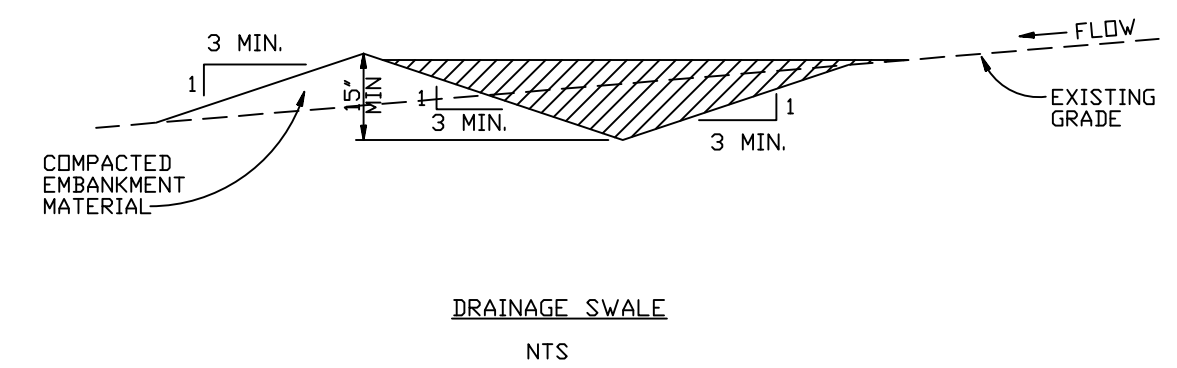
Previous comment:
 Page 3 of the PBMP Applicability Form shows LOD as 1.104ac. Revise to remove discrepancies.

Review #5 comment:
 Per latest comments in the FDR, this area should be listed as "1.497ac" (1.104ac + 0.393ac).

This row of text was added per my comment on the last submittal. This is not sufficient. Areas of cut AND areas of fill must be identified SEPARATELY to satisfy GEC Checklist Item "1". To satisfy this requirement, most engineers create a linetype for cut/fill and label one side of the line as "cut" and the other as "fill" throughout the plans.

Per comments in FDR revise this text callout. This area should be included within the proposed LOD

Unresolved previous comment: proposed grading outside of LOD and not connected to an existing contour.

Please ensure that the appropriate easements/permission for off-site work is obtained from CDOT. Please address any CDOT comments and label the easement area on the GEC plan as needed.

Unresolved previous comment: GEC Checklist Item "o" - callout as offsite grading.

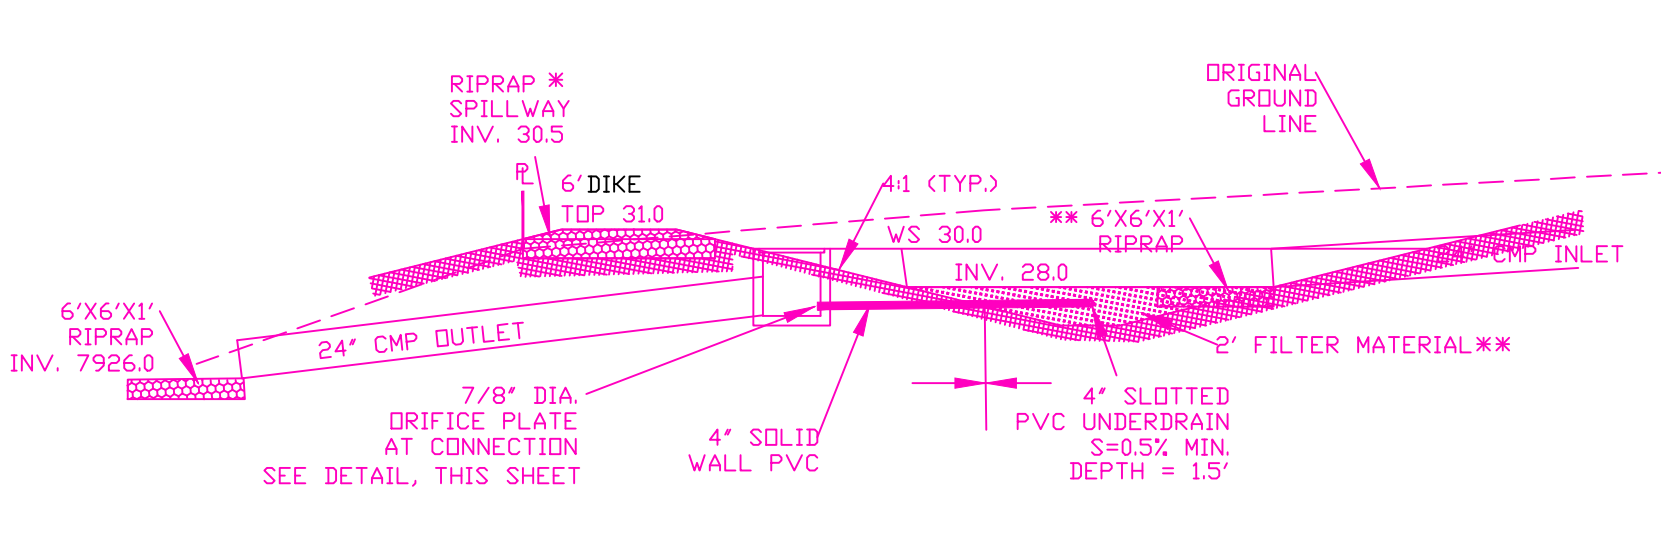
Unresolved previous comment: provide detail to show how orifice plate will be attached, what material it is made out of, etc.

Review #5 additional clarification: Show/detail things like:
 - Does the 4" pipe connect into the side wall of the 18" pipe?
 - How is the connection between the 4" and 18" pipes sealed?

clarify that the riser portion of the piping (the cleanout) is to be straight pipe. Whereas the rest of the underdrain is slotted pipe.

Unresolved previous comment: Per DCMv2 Section 4.3, outlet pipe should be 18" minimum. (UD Figure 6-a)

Revise to "CDOT Inlet Detail" or similar. Section A-A is for the spillway

where is this cleanout located on each SFB? Show and label on each plan detail on this sheet.

Invert of underdrain not shown in any details in this planset.

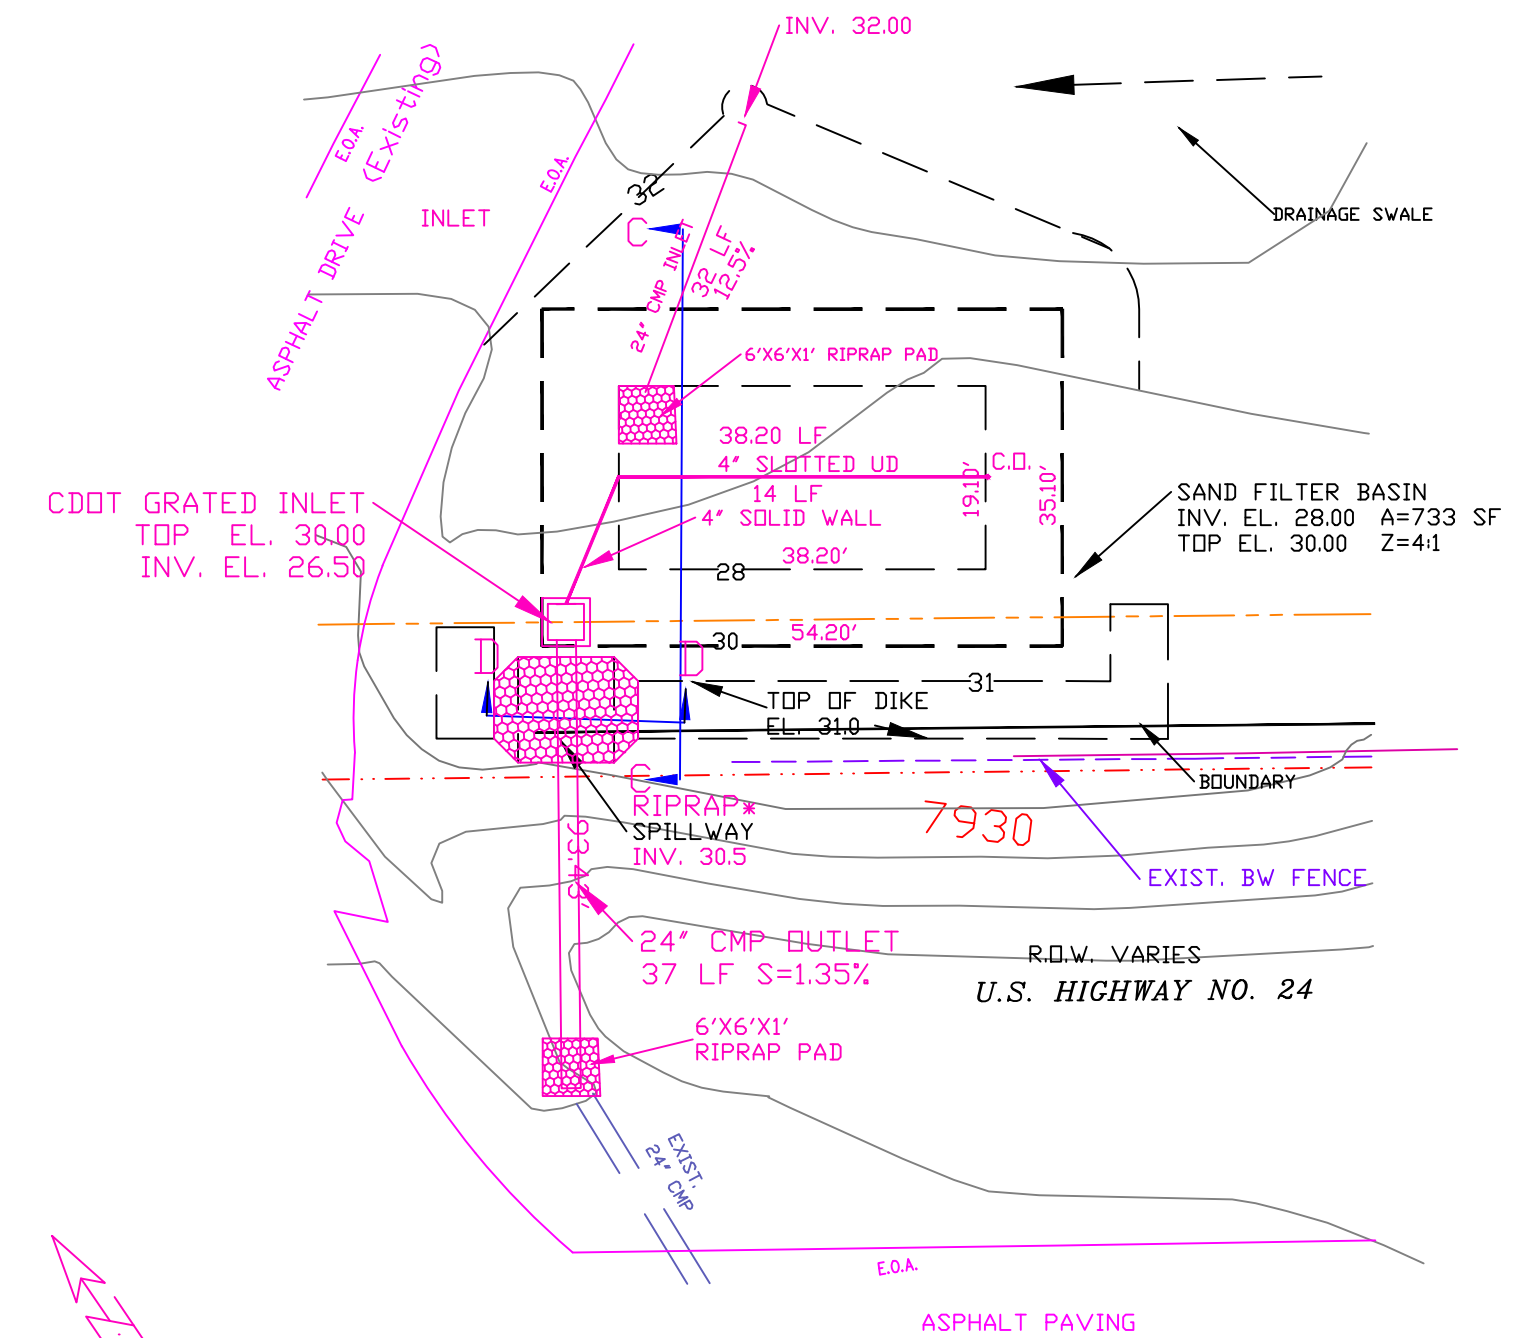
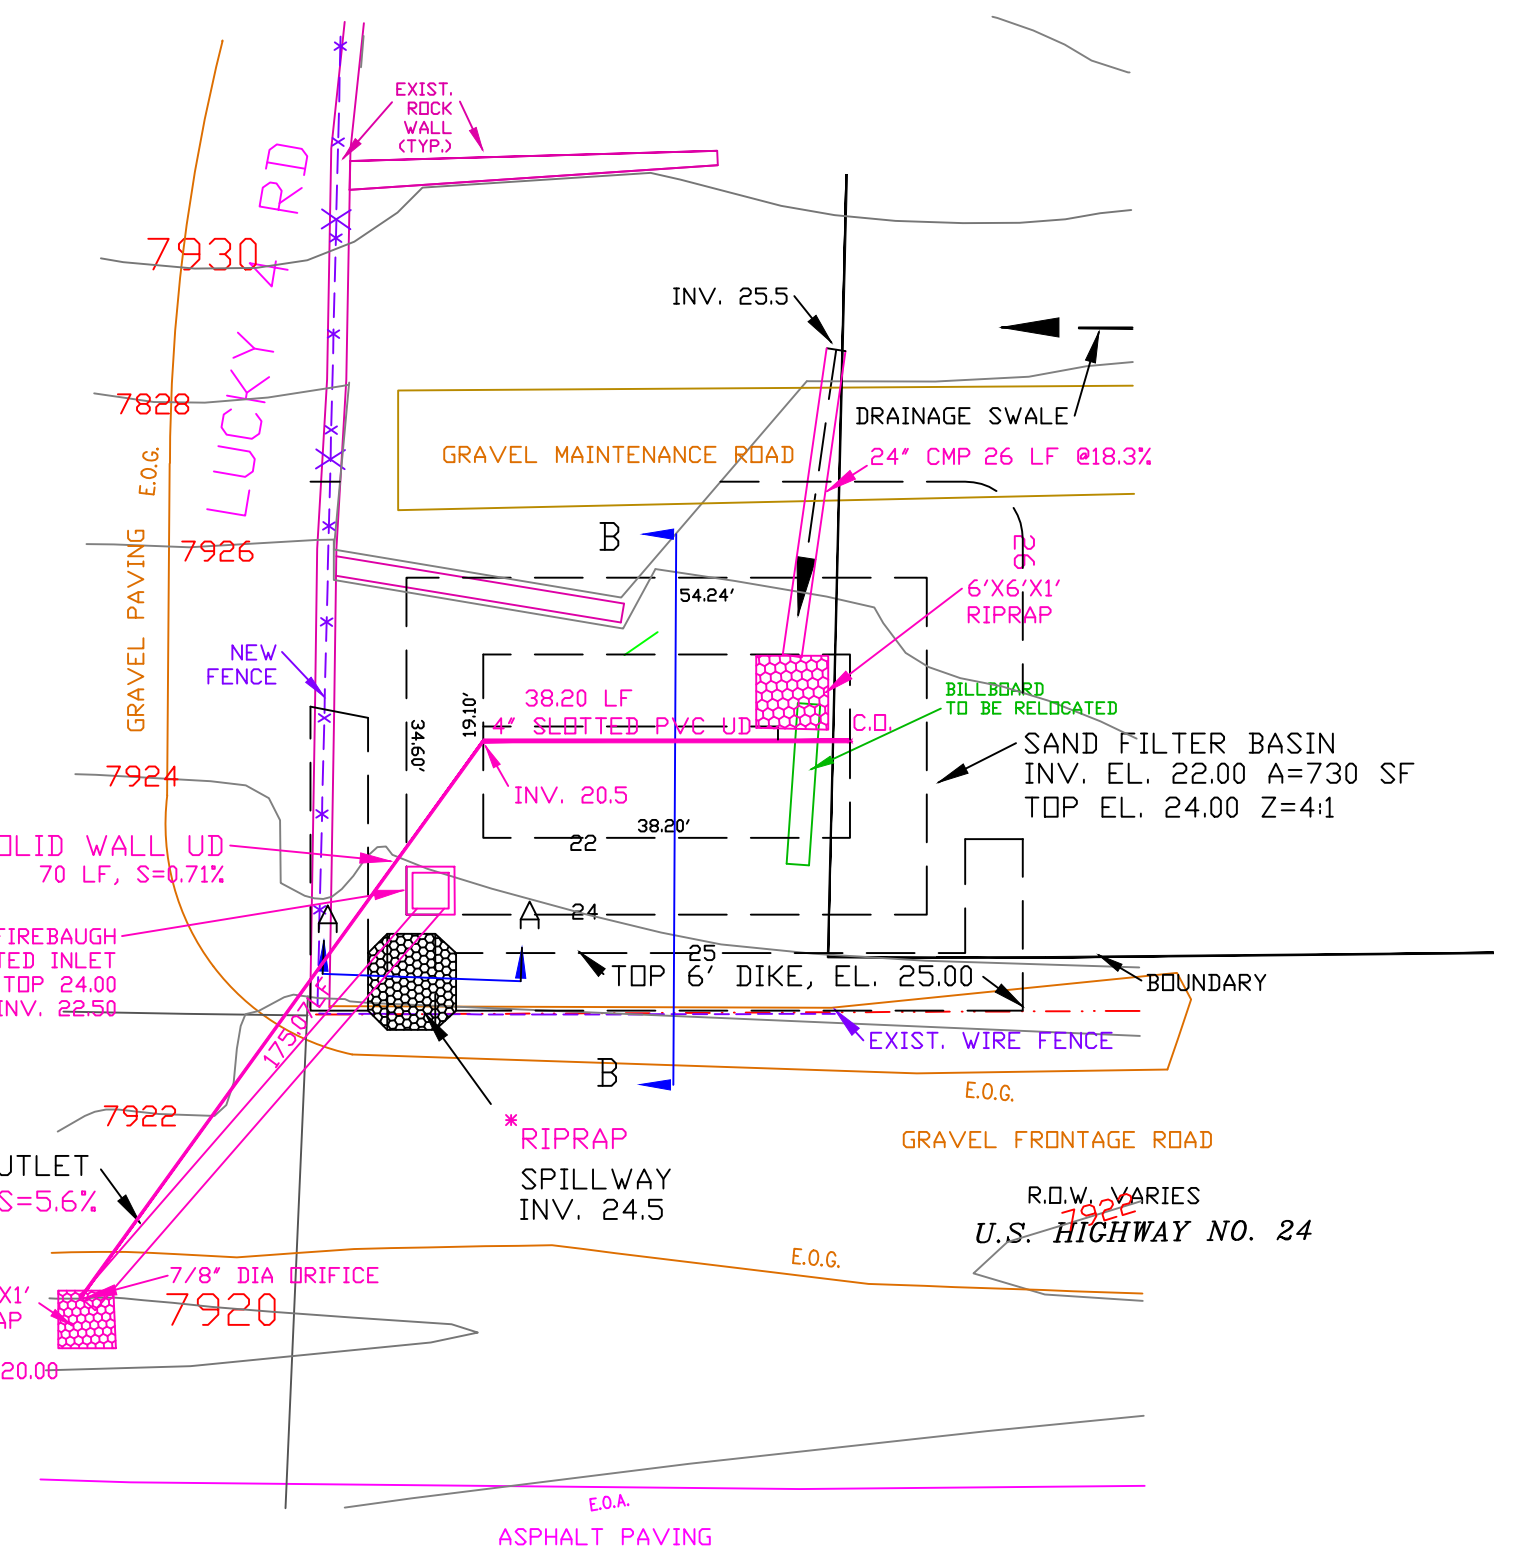
Unresolved previous comment: This type of soil riprap with topsoil is fine for the spillway but is not appropriate for the erosion protection at the bottom of the SFB where the inlet pipe outfalls. We don't want to encourage the growth of vegetation with the topsoil nor do we want to introduce more sediment into the SFB which will cause extra maintenance.

So create a separate asterisk or text callout for these locations.

Additional clarification for this submittal: Or clarify with revising text callouts as to which pads are soil riprap (via asterisks on each) and which are to be just riprap (ie: no soil, no asterisks). I have added individual notes to each text callout that I think needs to be revised.

Provide invert of outlet pipe

Unresolved previous comment: provide detail to show how orifice plate will be attached, what material it is made out of, etc.

Review #5 additional clarification: On the newly added Orifice Detail, also show/detail things like:
 - Does the 4" pipe connect into the side wall of the inlet box?

- How is the connection sealed between the pipes and inlet box?
 - I would also add a note detailing how you want the orifice plate installed. For example: the underdrain pipe could come through the inlet box far enough to get a cap on it (which will have the orifice on it). Otherwise, the pipe could instead be cut flush with the wall of the inlet box and it will be very difficult to install the cap (since there will be no room to then add a 4" PVC coupling), so the likely solution would then be to bolt a metal orifice plate to the side of the inlet box with a gasket (which will take more time and money). Summary: just clarify what you want to avoid errors in the field. We have previously seen in the field issues with the installation of the orifice plate because of lack of details on the drawings.
 Be clear that each SFB's orifice details are unique.

Unresolved previous comment: Clarify where the transition occurs from solid wall to slotted. Also show a section view of how underdrain is to be installed, as seen on pg SF-8 of MHFD Detail T-6

Review #5: the section view should show things like grading of subgrade, depth of underdrain in filter media, etc.
